SOUTH HOLLAND DISTRICT COUNCIL

Purpose: To consider Planning Application H16-0645-22

Description: Proposed change of use from vacant offices to HMO including erection of cycle/bin storage

Location: THE GRANGE 8 PINCHBECK ROAD SPALDING

DRAWING
Proposed Ground Floor
Plan

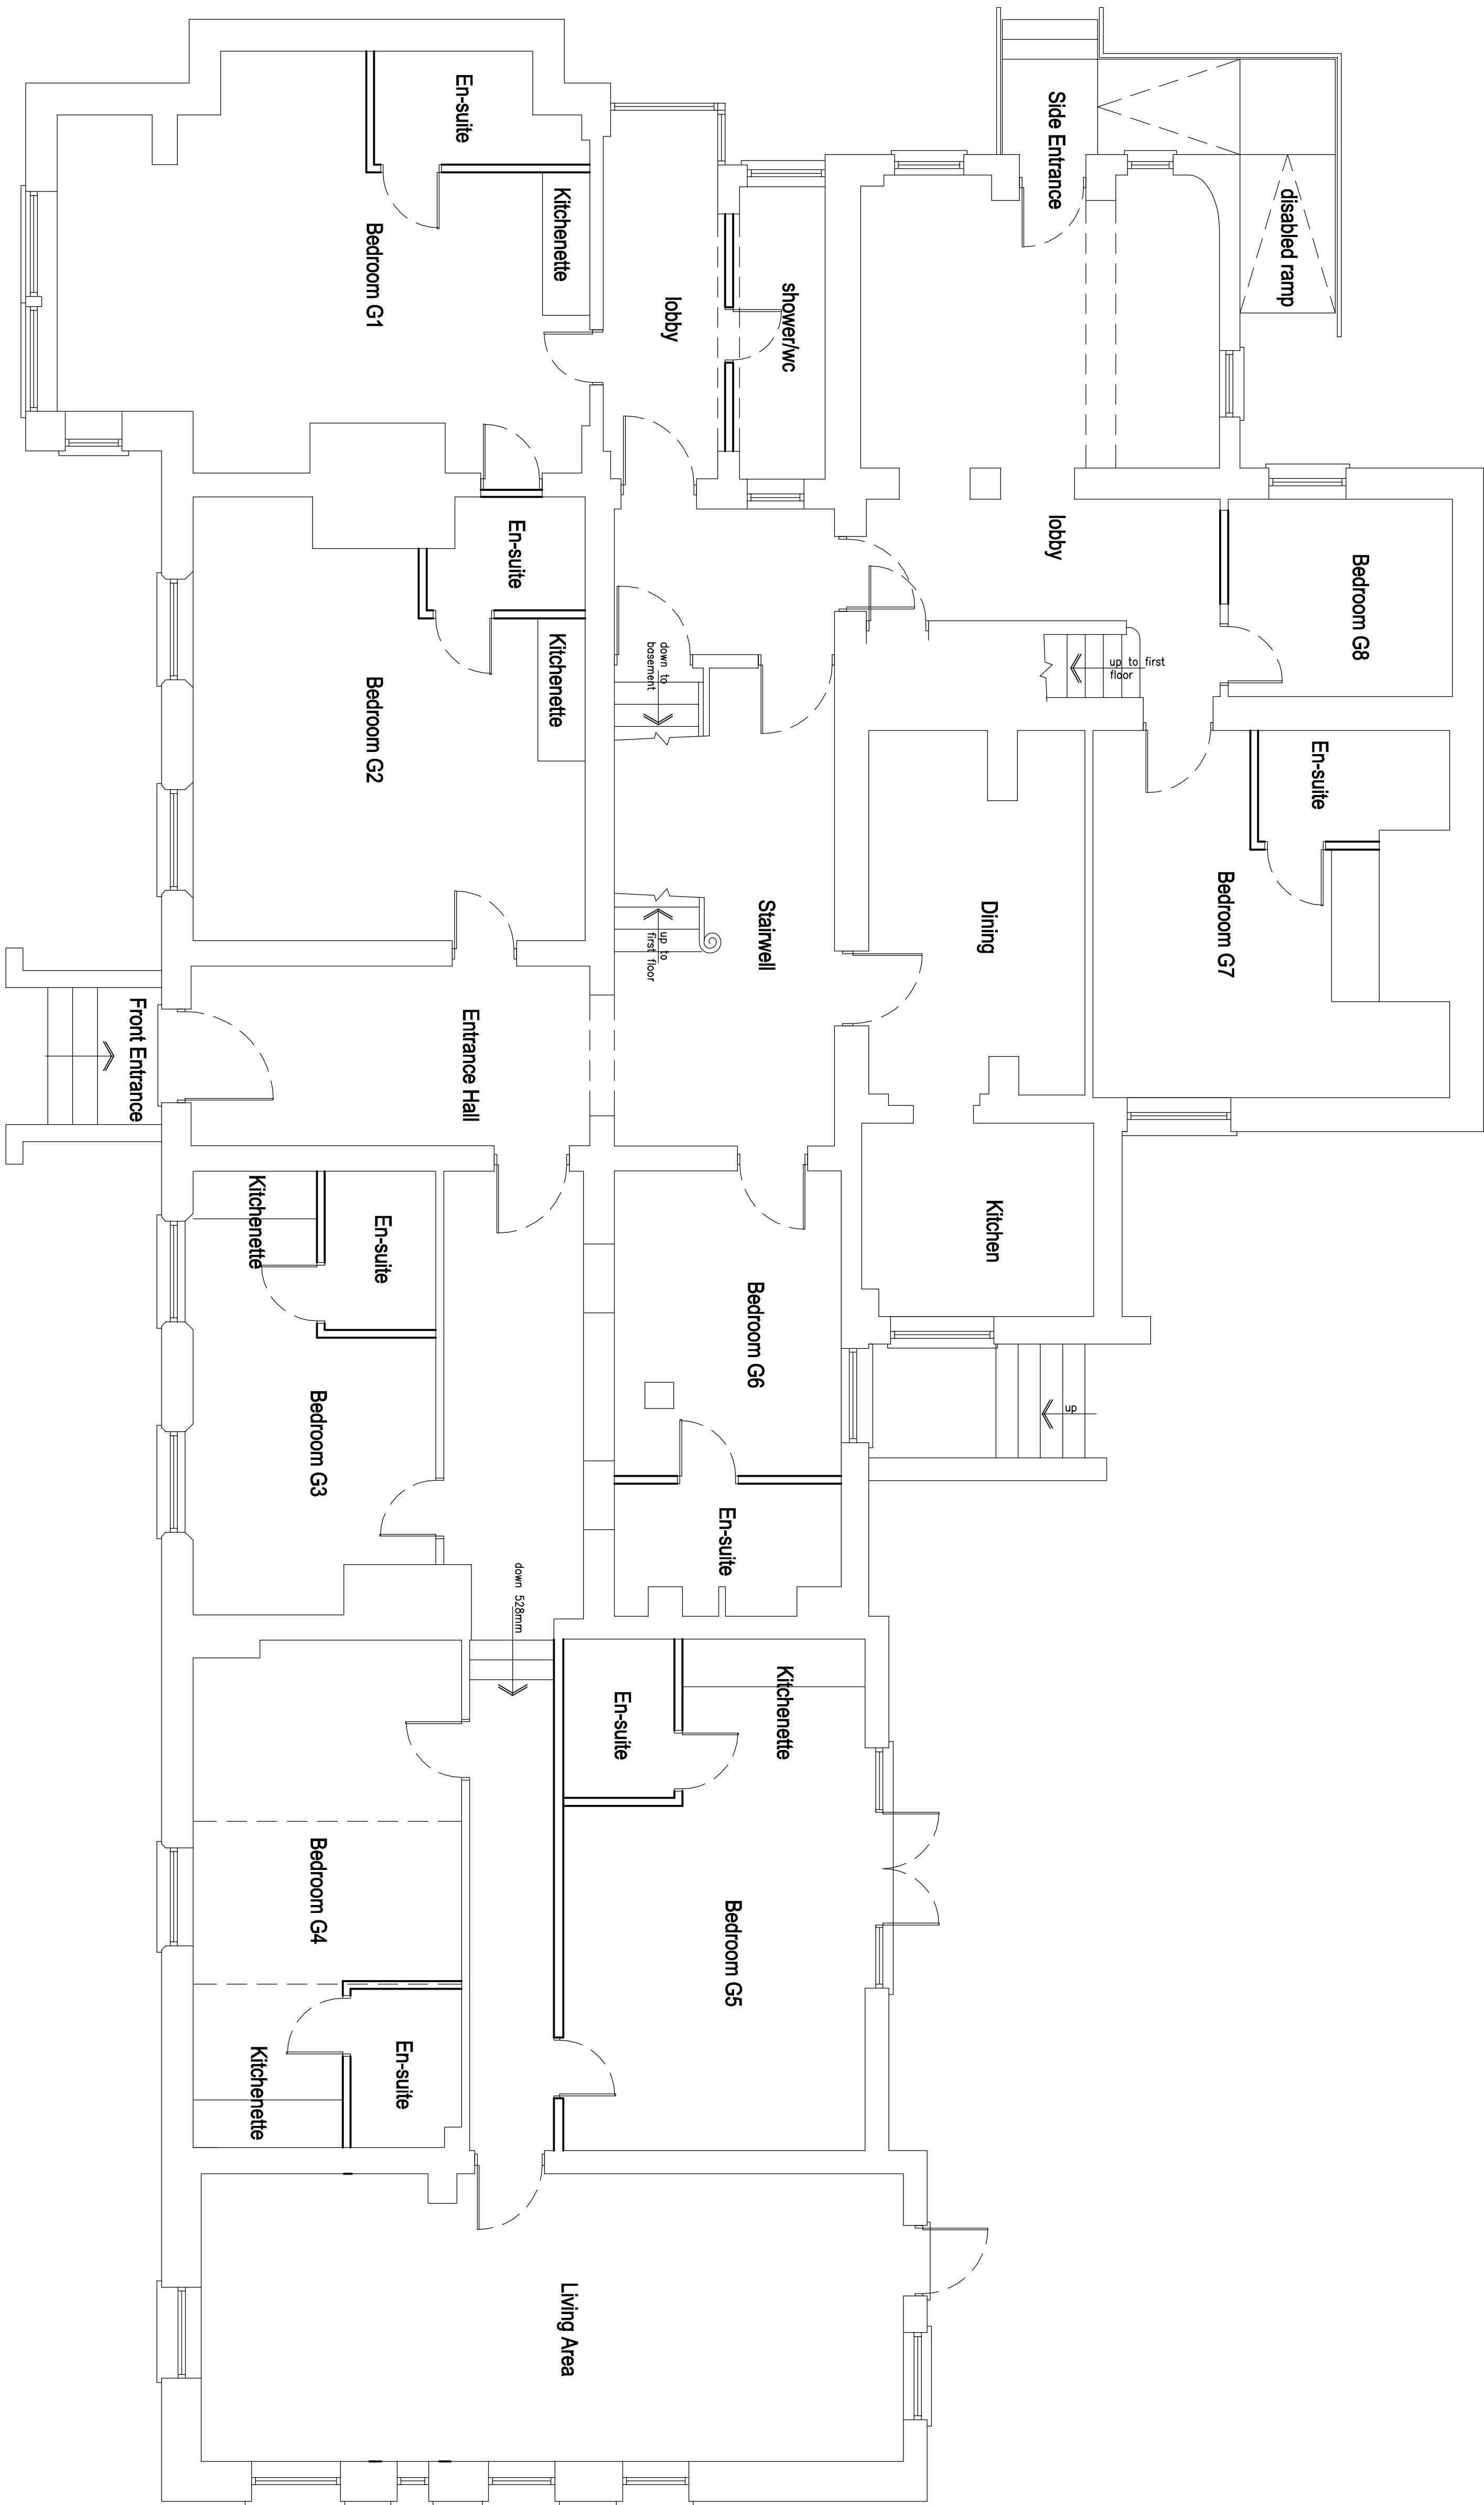
2.3 The works would also include the creation of an external disabled access ramp, as well as the conversion of the rear garden area to parking and amenity space. The plans indicate that 13 allocated parking spaces would be made available to the site.

- 7.10 Furthermore, the proposal to create a large, permeable hard-standing area to the rear in the extant garden area would be detrimental to the overall character of the site and with the removal of a garden space could hamper future efforts to restore the original single residential use by substantially harming and degrading of the quantity of open, private amenity space, via the addition of a large, unflattering car park to the rear of this property which currently enjoys and is partly characterised by its large garden.

3. The proposal to largely pave over the rear garden to the Grade II* listed building is deemed to be unacceptable in policy terms. The proposal to create a large, permeable hard-standing area to the rear in the extant garden area would be detrimental to the overall character of the site by substantially harming and degrading of the quantity of open, private amenity space, via the addition of a large, unflattering car park to the rear of this property which currently enjoys and is partly characterised by its large garden. It could be said that such a proposal in isolation would represent less than substantial harm to the site, however, Para 202 of the NPPF (2021) states that where less than substantial harm will be incurred by a proposal it can only be justified through weighing against the public benefit or it's contribution toward achieving the site's optimal use. It is not considered that there is substantial enough public benefit presented by this application and neither is a HMO considered to be the optimal use for this site and therefore, the inclusion of such a large alteration to the garden space does not assist in achieving an optimal use in any way. In this instance, it is clear from the history of the site and the numerous instances of pre-application advice that have been issued relating to this site that use as a single residential dwelling or minor subdivision into a small number of large apartments is considered far more optimal. Therefore, the proposal falls short of the requirements of Policy 29 of the South East Lincolnshire Local Plan (2019) which established under Policy 29, Section A that all proposals effecting listed buildings should only be accepted where the Local Planning Authority is satisfied that the works are in the interest of the listed building's preservation and do not include proposals which are prejudicial to the special architectural or historic interest of the building or its setting. Furthermore, Policy 29, Section A confirms that developments effecting Listed buildings should only be approved where they preserve or better reveal the asset's significance.

Proposed First Floor Plan

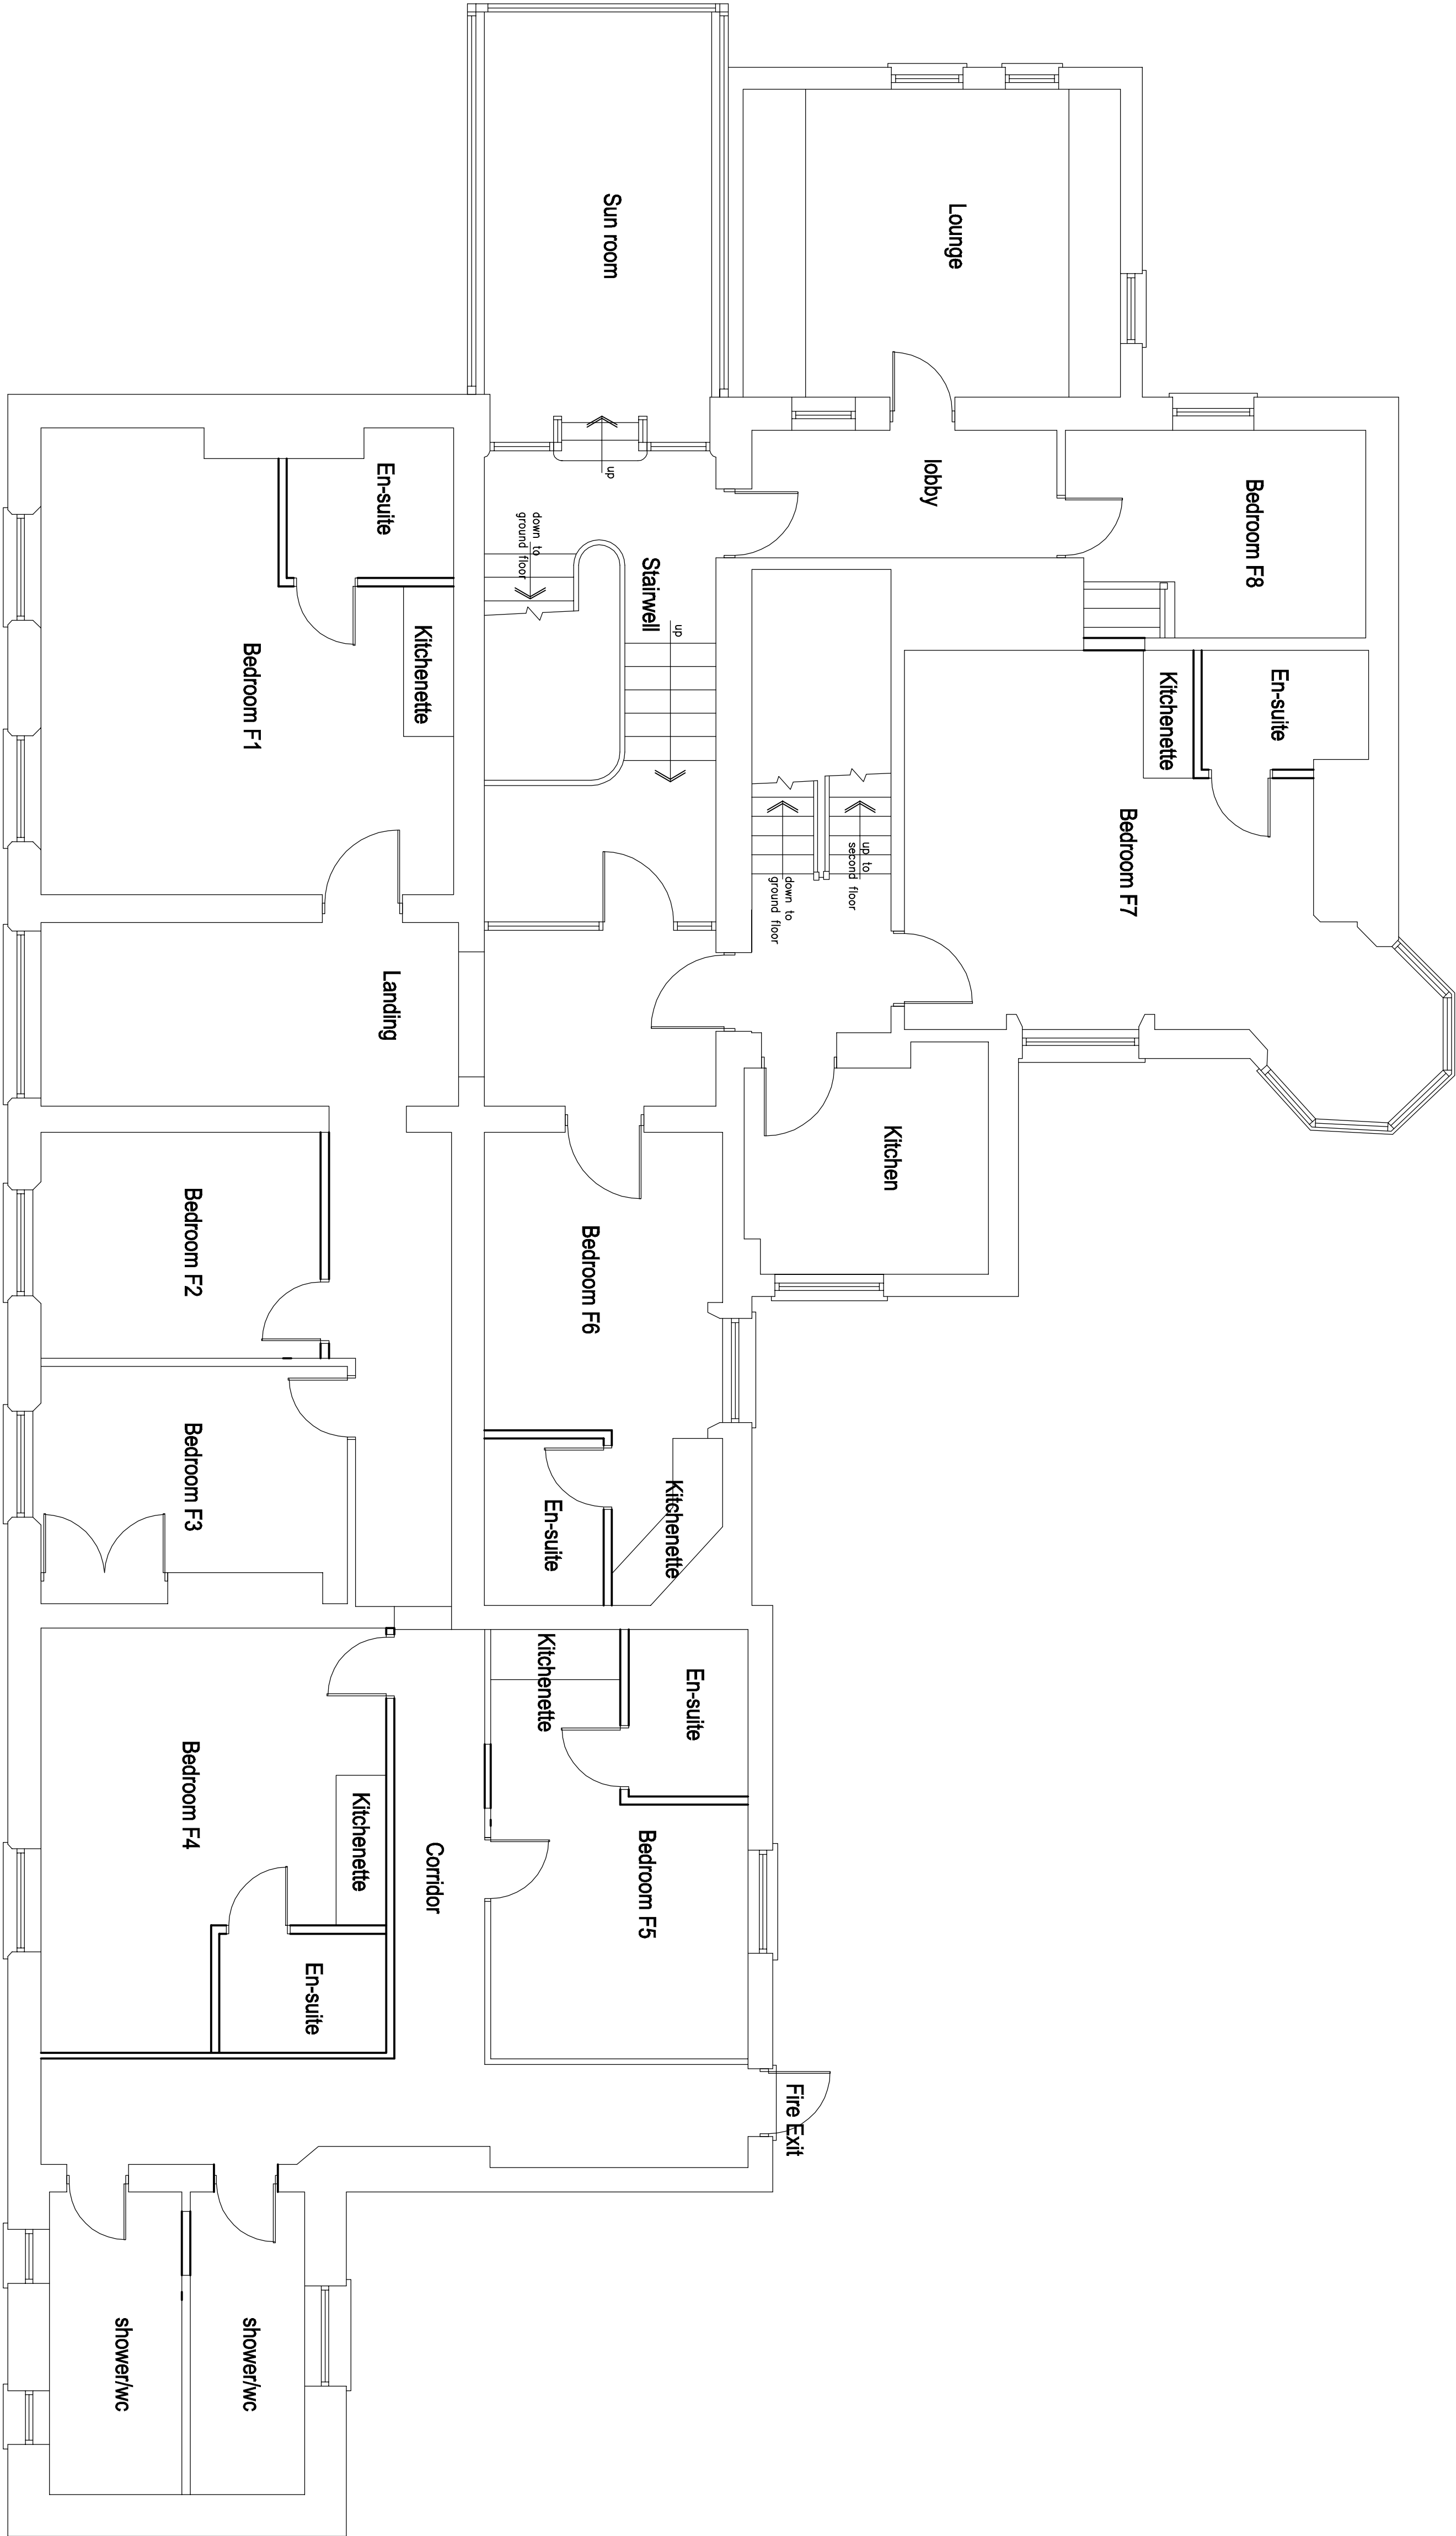
- 7.9 Whilst it is accepted that the proposed alterations could be reversible and that historic alterations have already modernised the interior to a certain extent, to allow such a major adjustment of layout, with subdivision of many of the liveable rooms to accommodate en-suite bathrooms and other facilities necessary on a unique scale with HMO development would set an uneasy precedent, most especially when relating to a Grade II* listed property, particularly when the scale of such rooms (for instance the room marked F7 on plans, featuring the Oriel window) being of importance to the character itself.

2. As a grade II* listed property, the proposed additional and extensive subdivision of the property would lead to a substantially detrimental impact upon the remaining character of this site and would establish a much altered internal layout rendering much of the original floorplan further unreadable, causing a harmful effect upon appreciation of the heritage asset. Therefore, the proposal falls short of the requirements of Policy 29 of the South East Lincolnshire Local Plan (2019) which established under Policy 29, Section A that all proposals effecting listed buildings should only be accepted where the Local Planning Authority is satisfied that the works are in the interest of the listed building's preservation and do not include proposals which are prejudicial to the special architectural or historic interest of the building or its setting. Furthermore, Policy 29, Section A confirms that developments effecting Listed buildings should only be approved where they preserve or better reveal the asset's significance.
